KITTITAS COUNTY

MEMORANDUM

DATE: December 5, 2007

SUBJECT: Additional Information Requested
Big Buck Ridge Plat

PROJECT#	SHEET: 2
2007-389	OF: 3

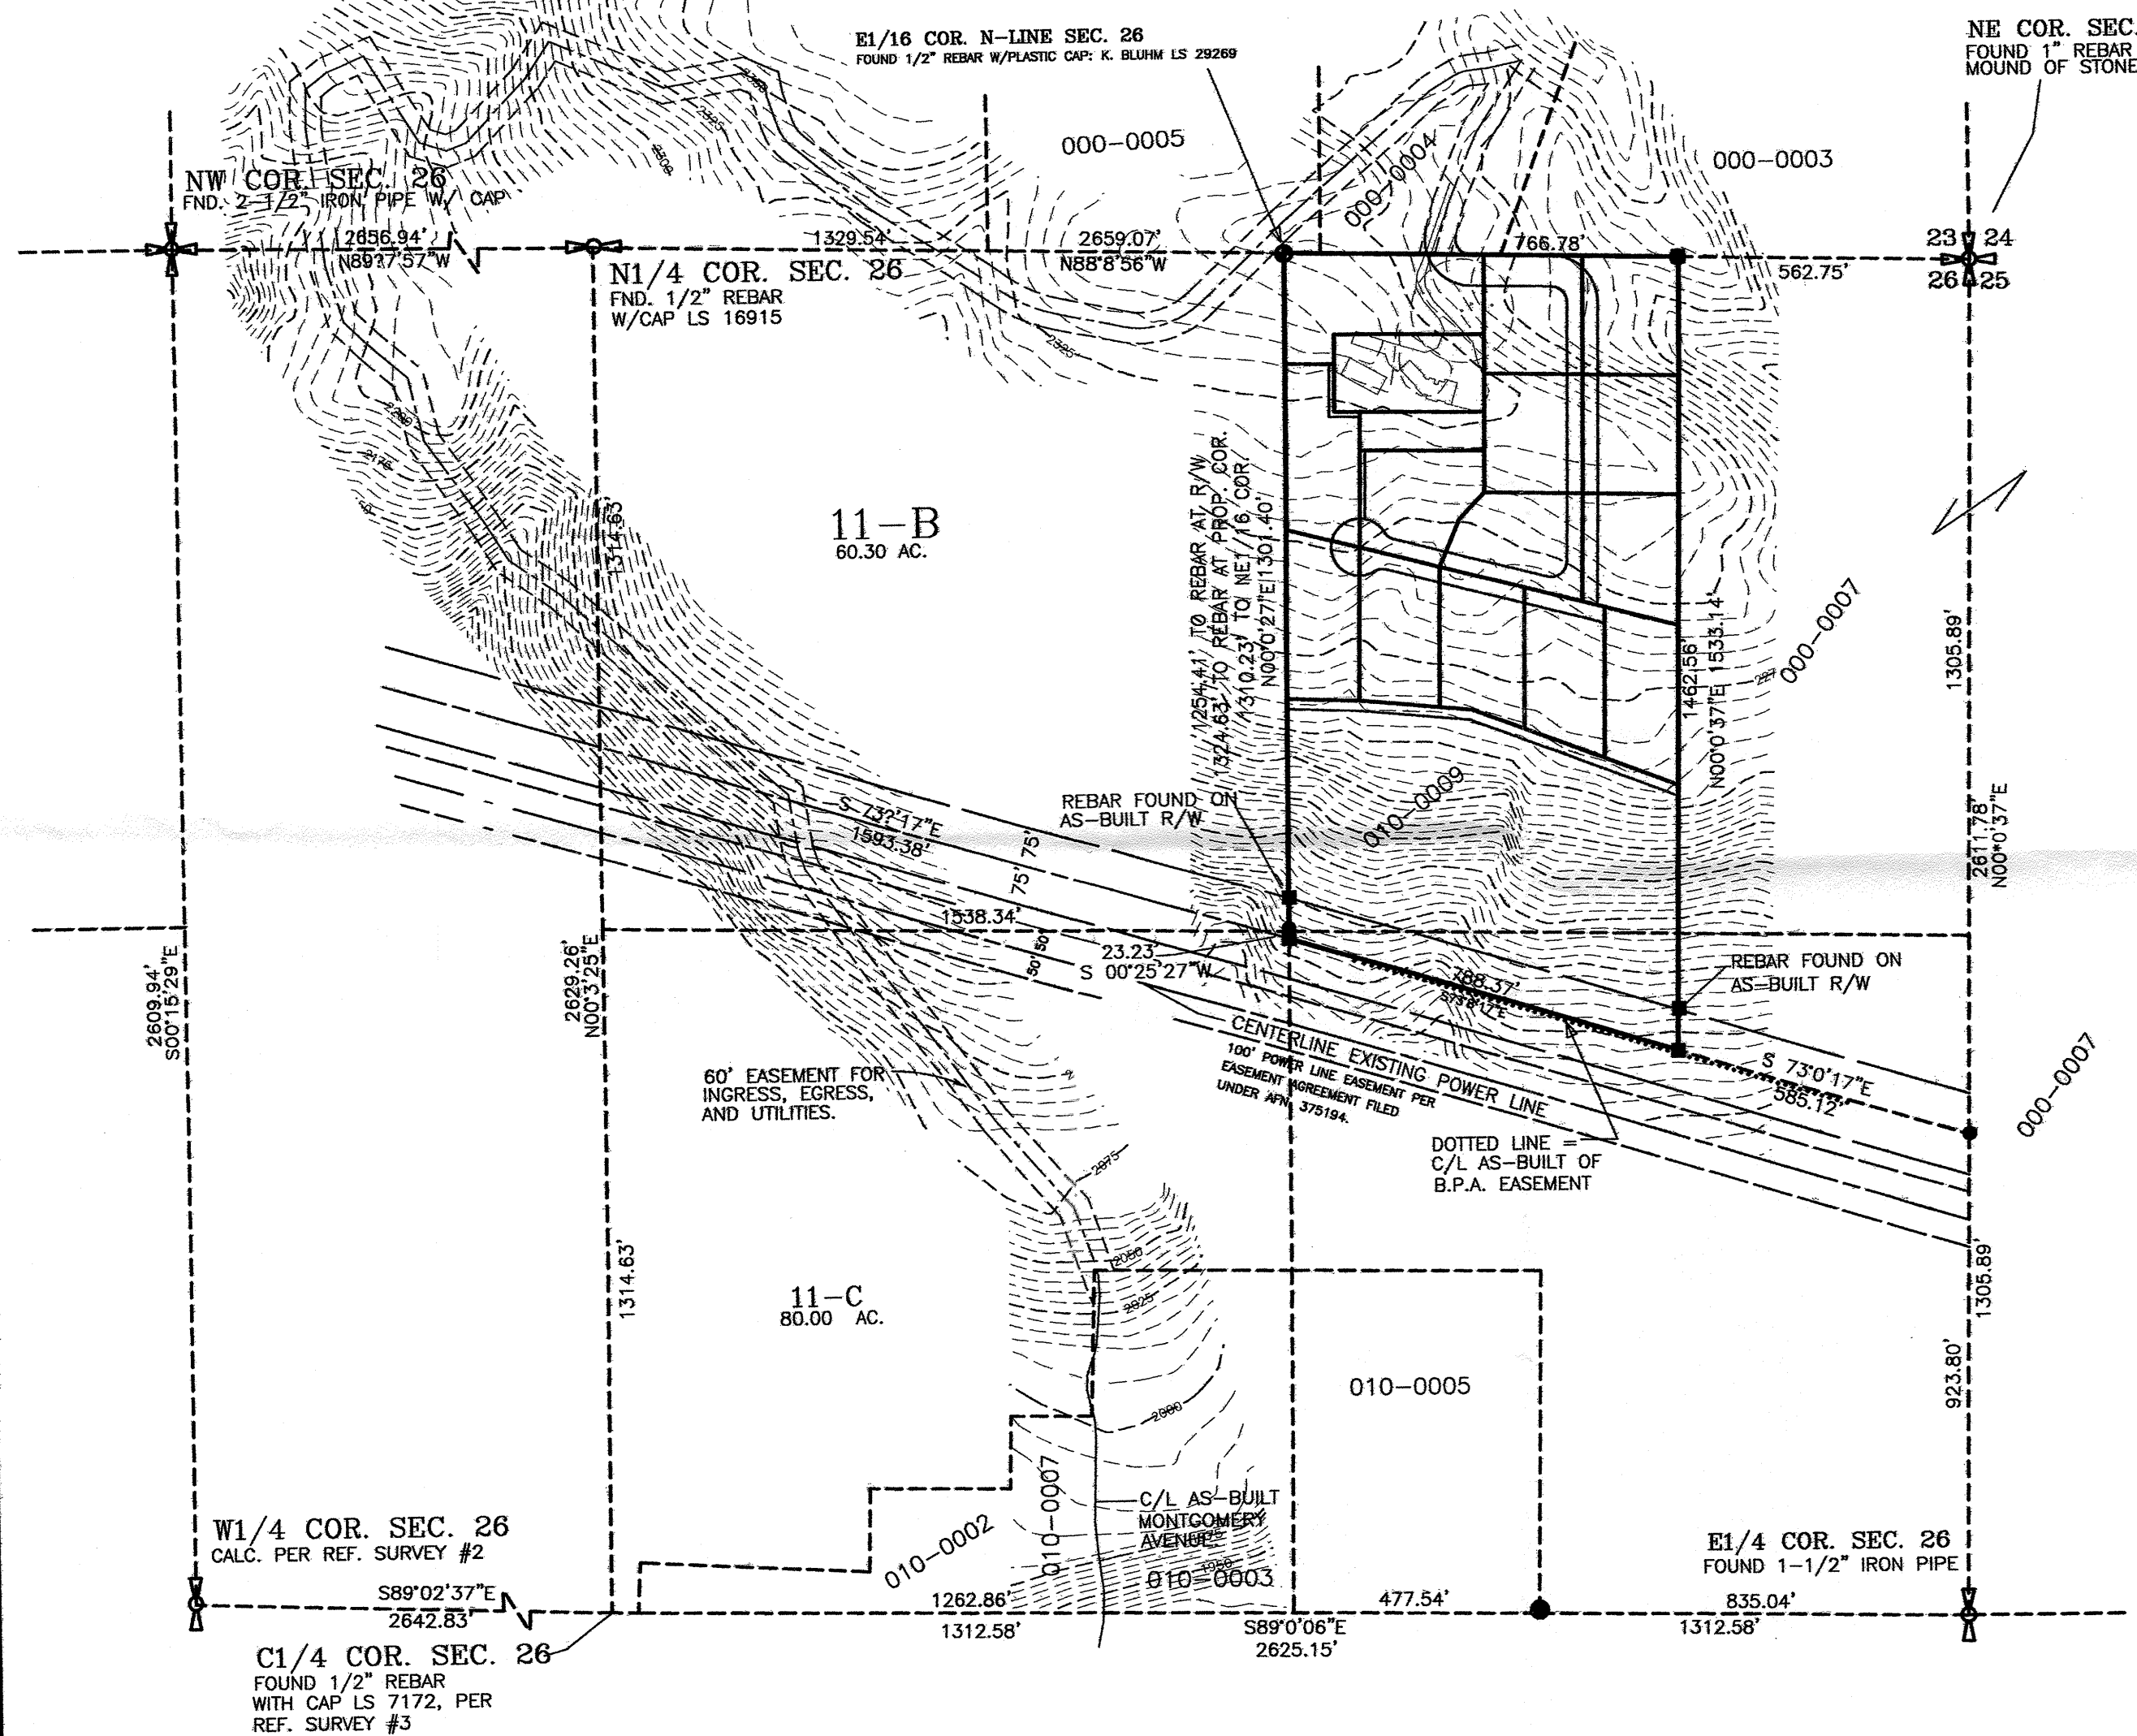
Deer Creek Road currently serves more than 40 lots. Per Kittitas County Road Standards 12.01.095(2), a second access is required. The second access shall be identified prior to preliminary approval.

All roads that serve more than 40 lots are required to have two interconnected ingress-egress routes that independently connect to an on-system county road.

If the second access is restricted to emergency access only, it must meet or exceed the following requirements: 60' easement, 20' roadway width, BST/ACP surface, and a paved apron. Access restrictions such as gates or bollards must be approved by the Fire Marshall.

If the second access is to be used for ingress and egress, it must meet the same standards of the first access.
